PLANNING APPLICATION 6/2019/0918/HOUSE **(NORTHAW PLACE, COOPERS LANE, NORTHAW)** **RAMBLERS SUBMISSION**

4. This is my submission regarding planning application (PA) 6/2019/0918/HOUSE (Northaw Place, Coopers Lane, Northaw), made within the 28th May 2019 deadline. It is an attachment to my comment in the comments box for this application on your website.

Drg. No
747 / SP3

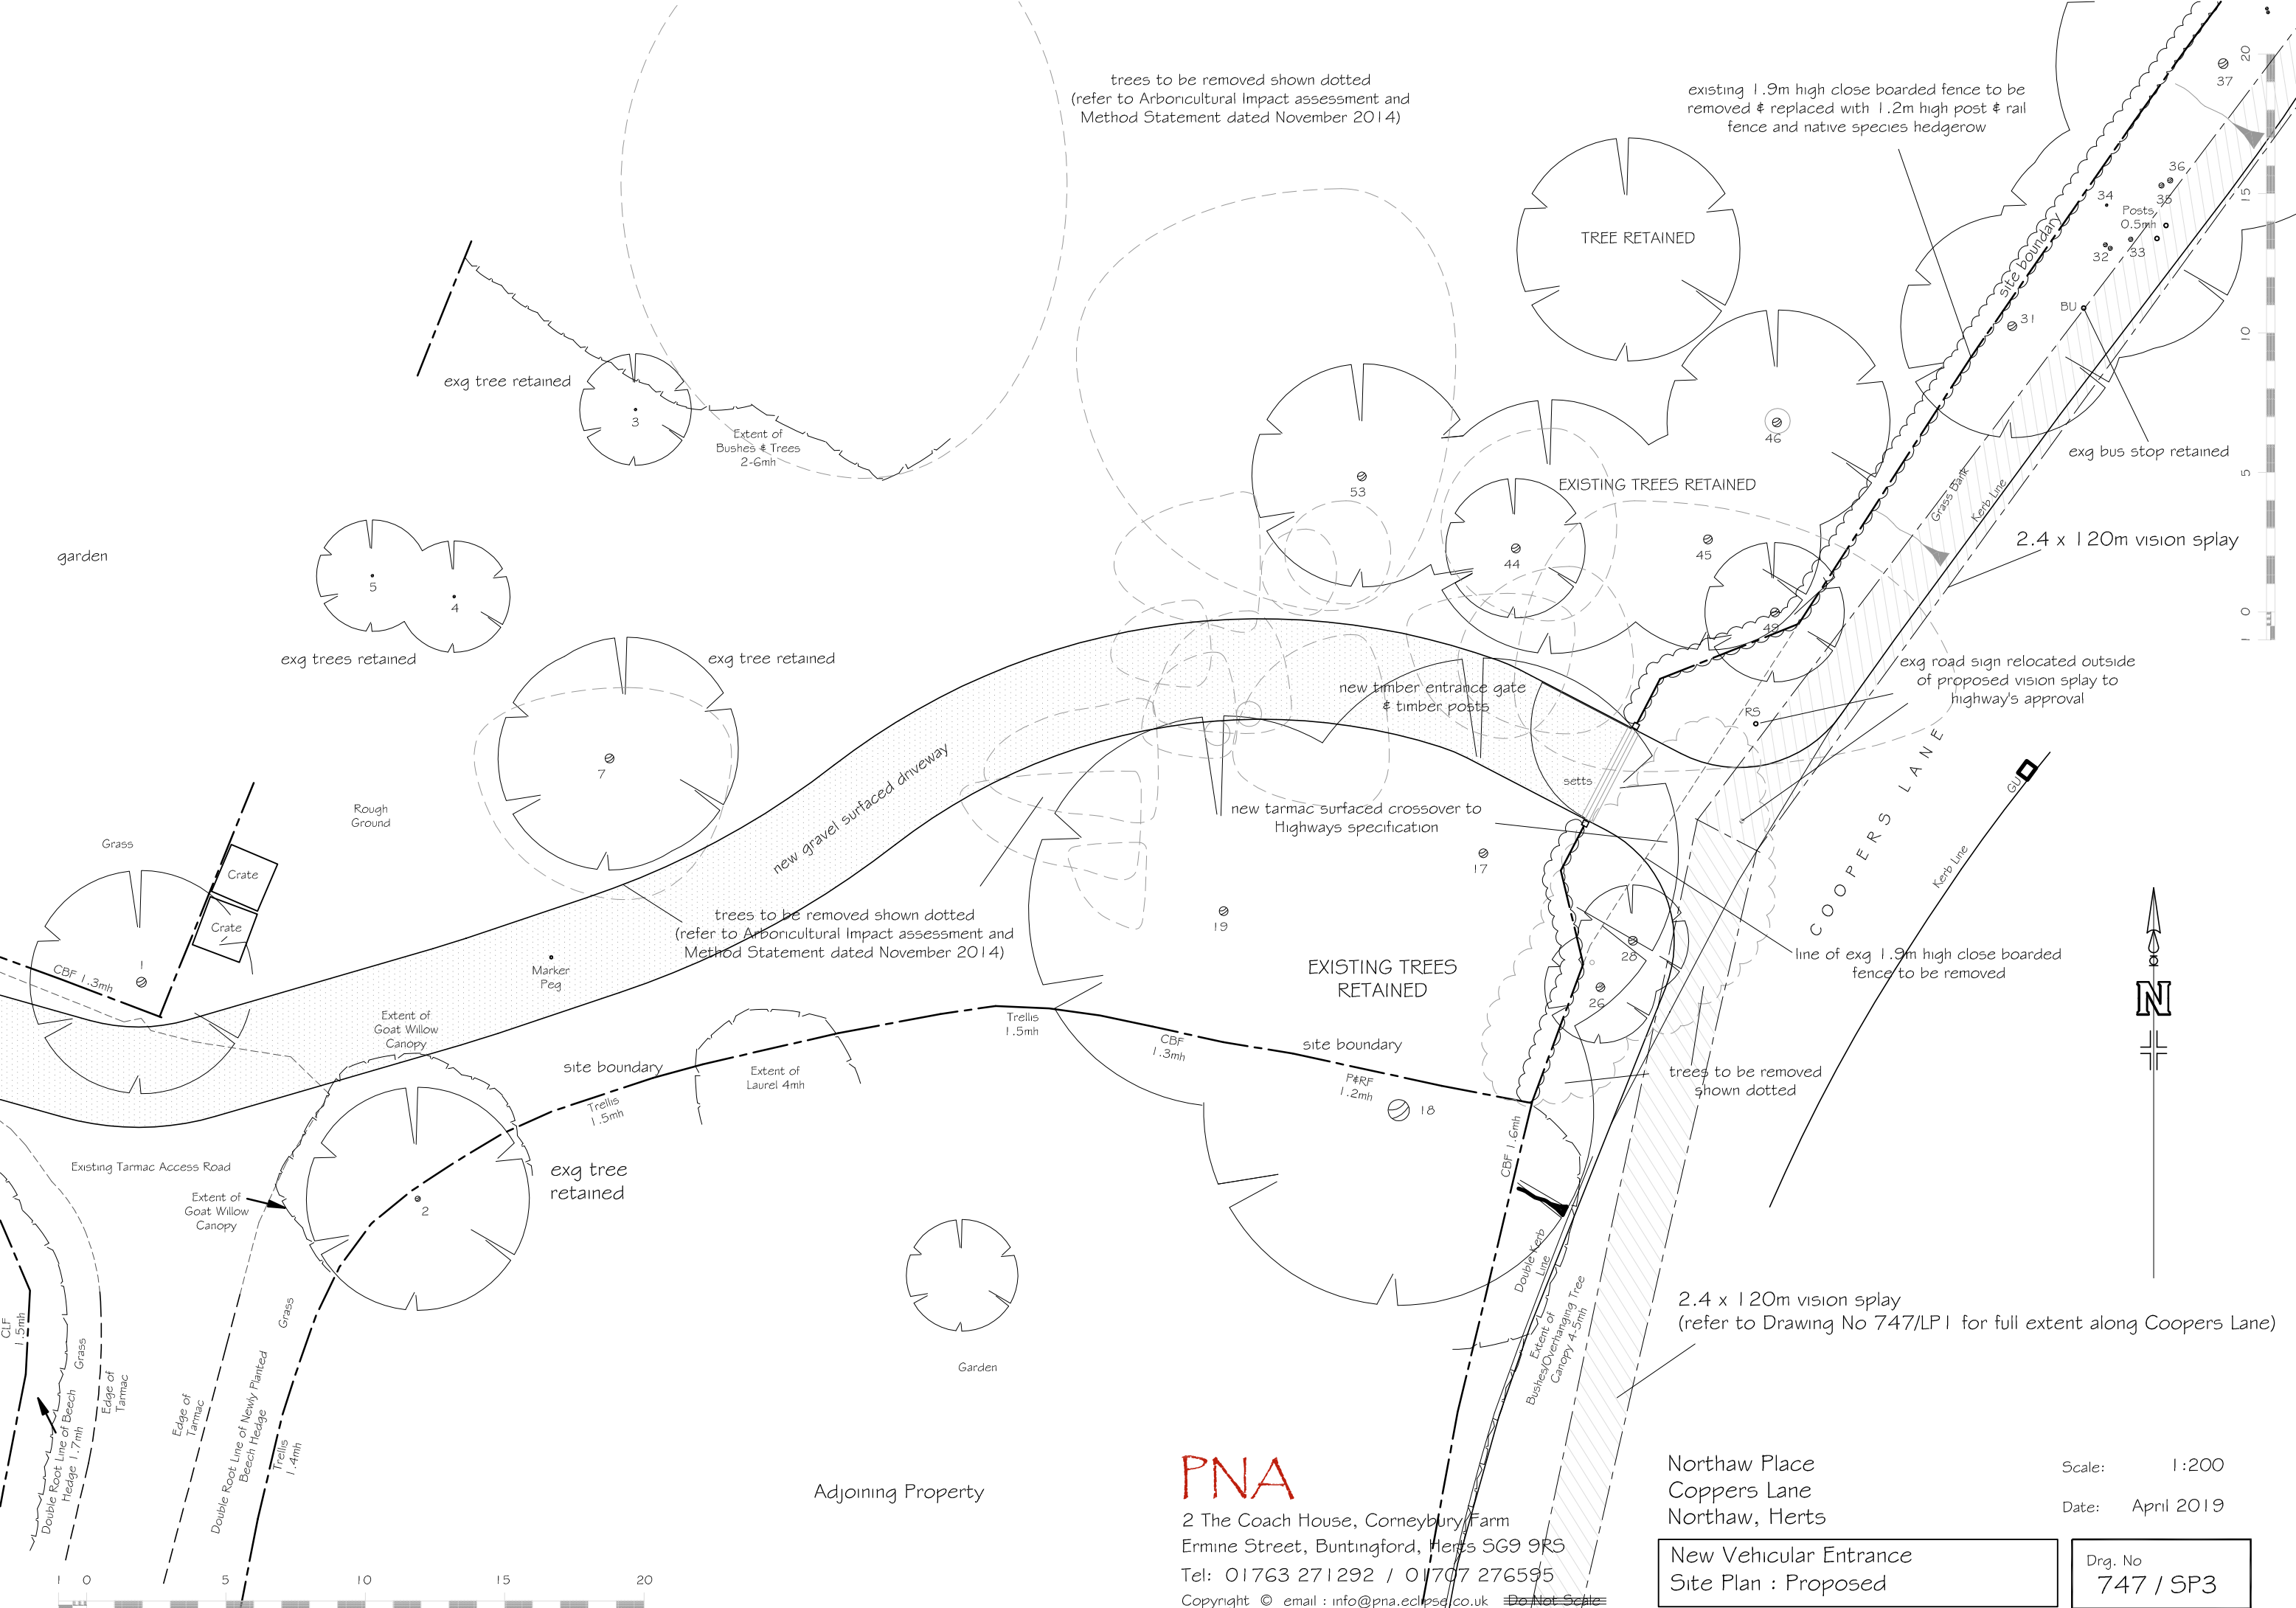
6. The footpath, in particular where it presumably abuts the northern end of the proposed replacement post and rail fence, should not be affected as a result of the works. Furthermore, during the works, and beyond, full continuous safe access to, and use of, the footpath should be maintained, with safety signage when appropriate during the works. If one or more temporary closures become unavoidable during the works, any such temporary changes should be kept to the minimum and be carried out in full compliance with the law, through Hertfordshire County Council's CROW Service.
